Planning Application No: 3/2026/0477

Proposal: Proposed refurbishment, partial demolition and extension to existing dwelling.

Location: Moorcot, Nickey Lane, Mellor BB2 7HF

Having reviewed the documents submitted Lancashire County Council acting as the highway authority makes the following initial comments and requests further information.

Client: Nigel Stones		
Project: Proposed Alterations Moorcot Nickey Lane Mellor		
Dwg title: Existing Site Plan		
Scale @ A4: 1:200	Date: 24.06.26	Drawn by: PD
Drawing no. 1861 - 101		Rev. B

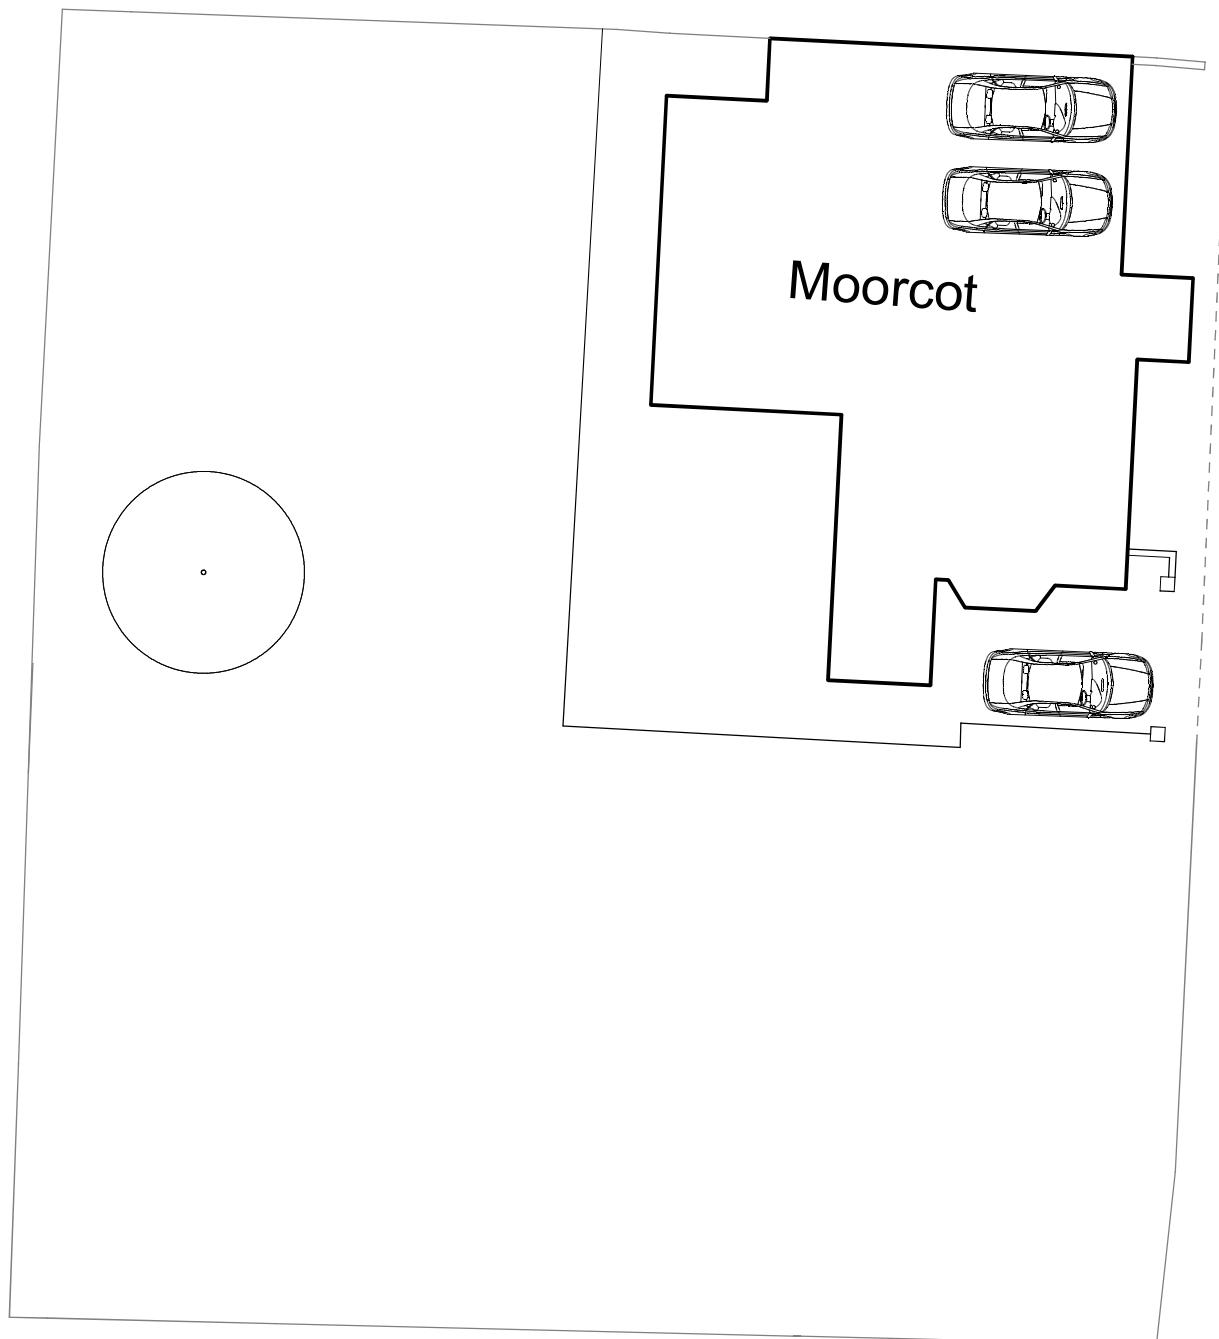
- The Proposed Site Plan shows the two parking spaces internal, but the Proposed Floor Plan shows these as external.
- The front boundary wall between the hardstanding and the footway in front of No 22 is not shown on the existing or proposed floor plans, nor on the existing or proposed site plans. This needs to be shown on all the plans. If this wall is within the applicant's ownership then the highway authority recommends that this is reduced in height by one and half courses of bricks to improve visibility to and from the hardstanding. The applicant should also confirm whether this is going to be reduced in length.

| Drawing title:<br>Proposed East Elevation                            |          |           |

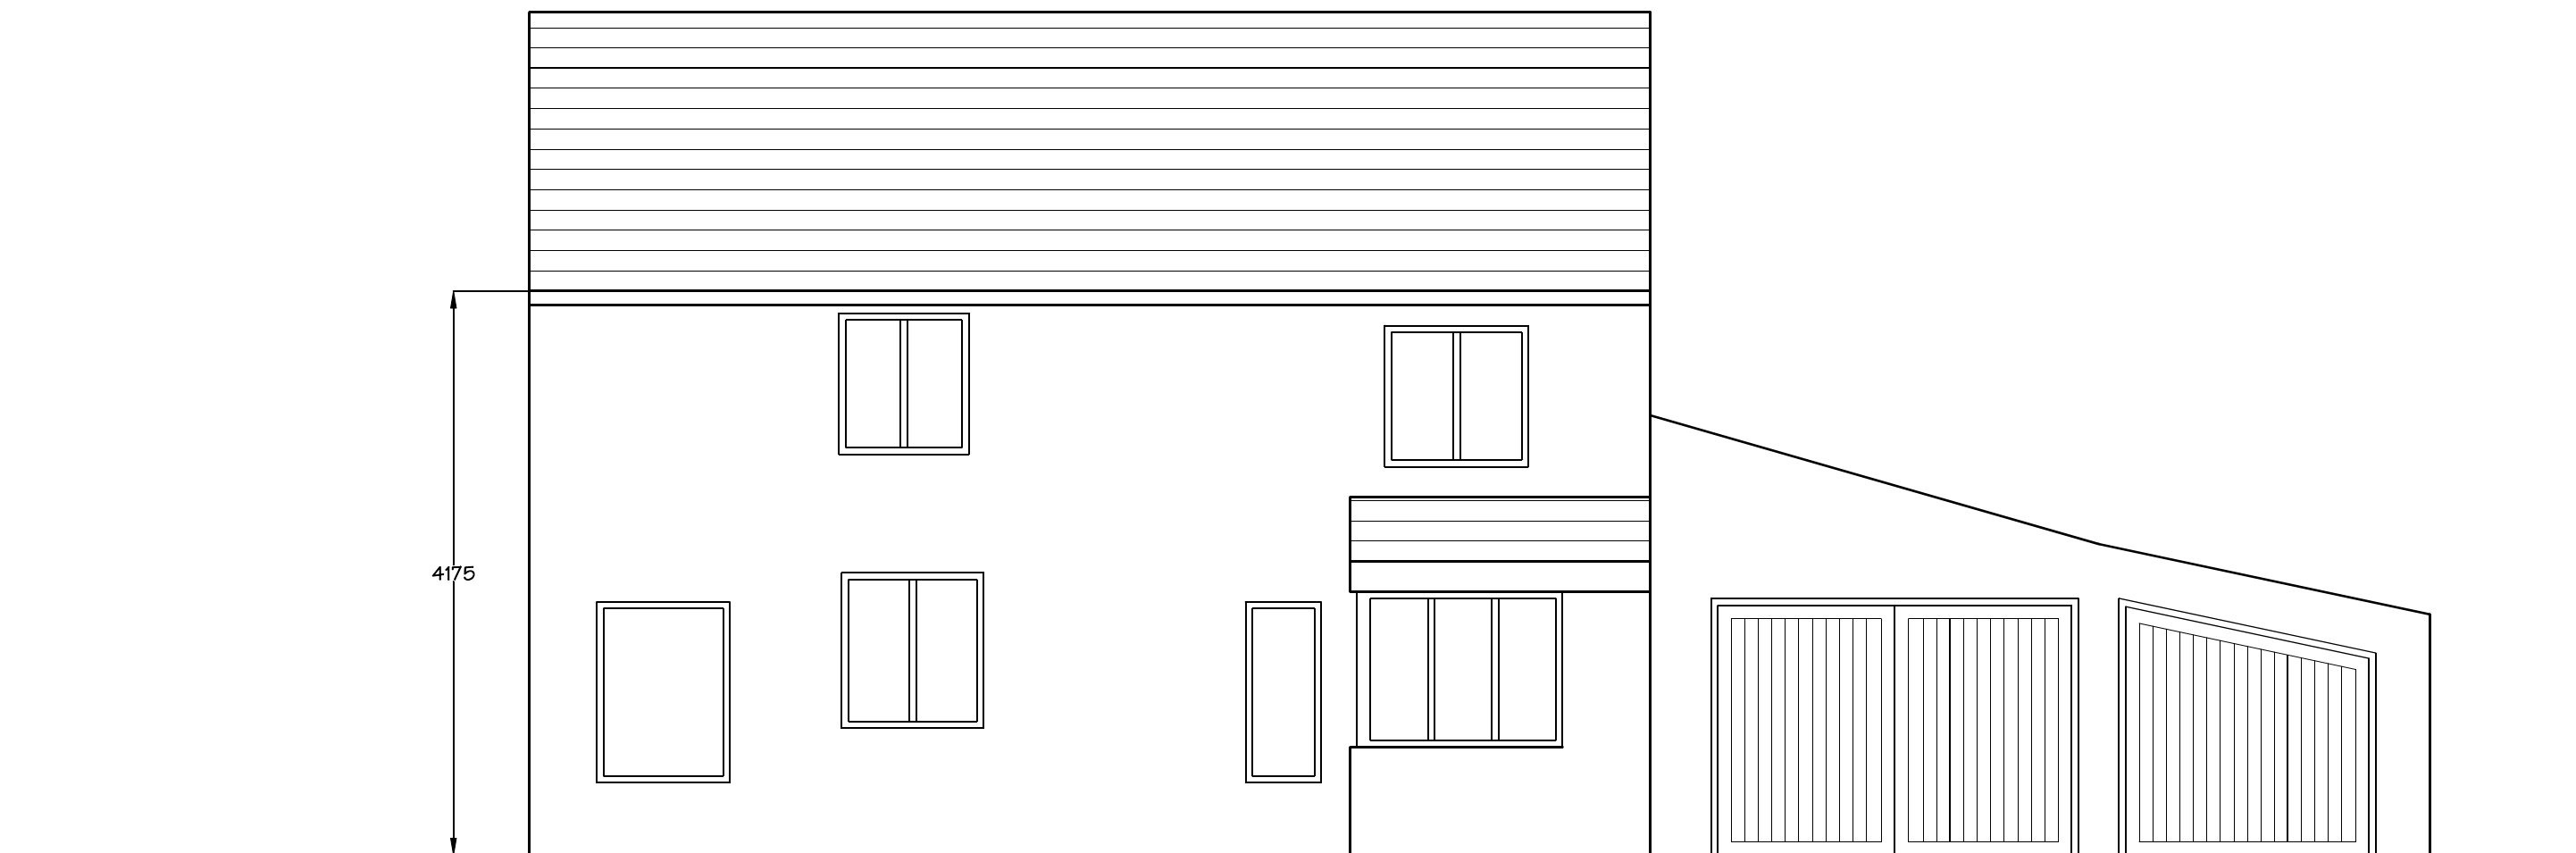
- The Proposed East Elevation plan (drawing 1816-08) shows the two separate garages doors as on the existing elevation plan. However the Proposed Floor Layout (drawing 1816-06) shows a pedestrian doorway which is not shown on the elevation plan, nor does it show the garage doors opening. Are the garage doors being retained purely from an aesthetic point of view rather than functional?
- The front wall, which was previously the garage wall, also appears to have been set back into the site to increase the area of hardstanding in front. Is this correct? Is this going to be a partial car port?
